Sent: 13 November 2013 19:36
To: Planning
Subject: Welwyn Hatfield Council Online Planning - Comment

Application Number: N6/2013/1938/MA

Address: 77 Hardings, Welwyn Garden City, Hertfordshire, AL7 2HA Comment Type: Object

Title Proposed Materials

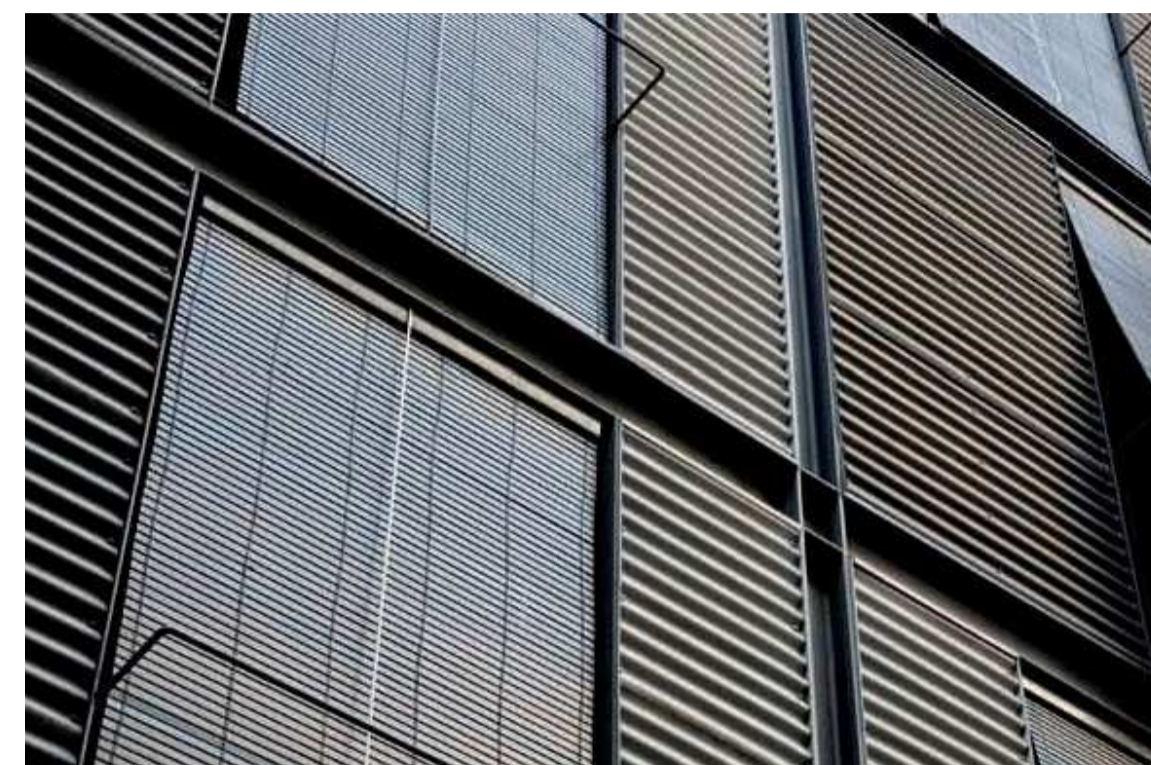
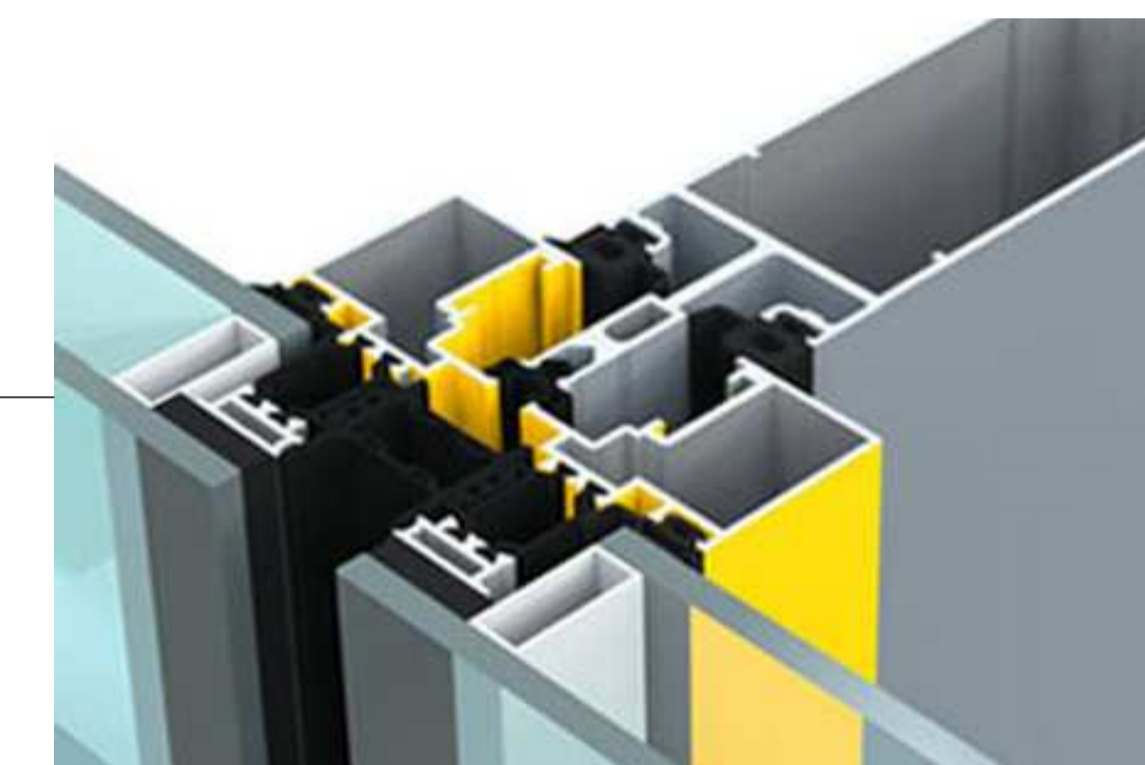
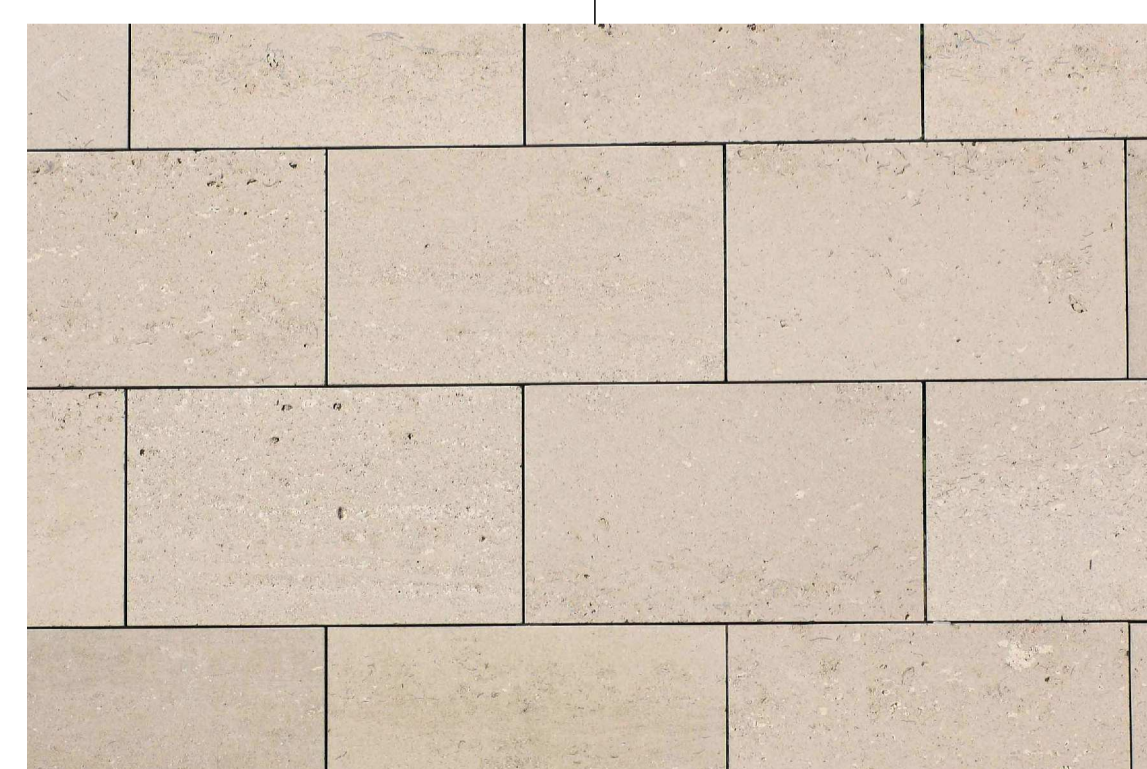
Comment: I wish to object to the amended planning application for all the reasons given in my original objection statement of the 3rd October 2013. The only change I can make out from the artist's impression of the amended exterior is that the connecting elevations between the existing building and the overbearing glass portico is that these are now intended to be constructed of matching brick (which we were given to believe by the council were now unobtainable).

In an interview yesterday with BBC Three Counties Radio, the leader of the council, John Dean, argued that the changes now meant that the glass portico represented a mere 20% of the new construction. As can be seen by these amended plans this is quite obviously wildly misleading. It can be clearly seen that the vast majority of the new facade is glass and demonstrably not subservient to the existing building.
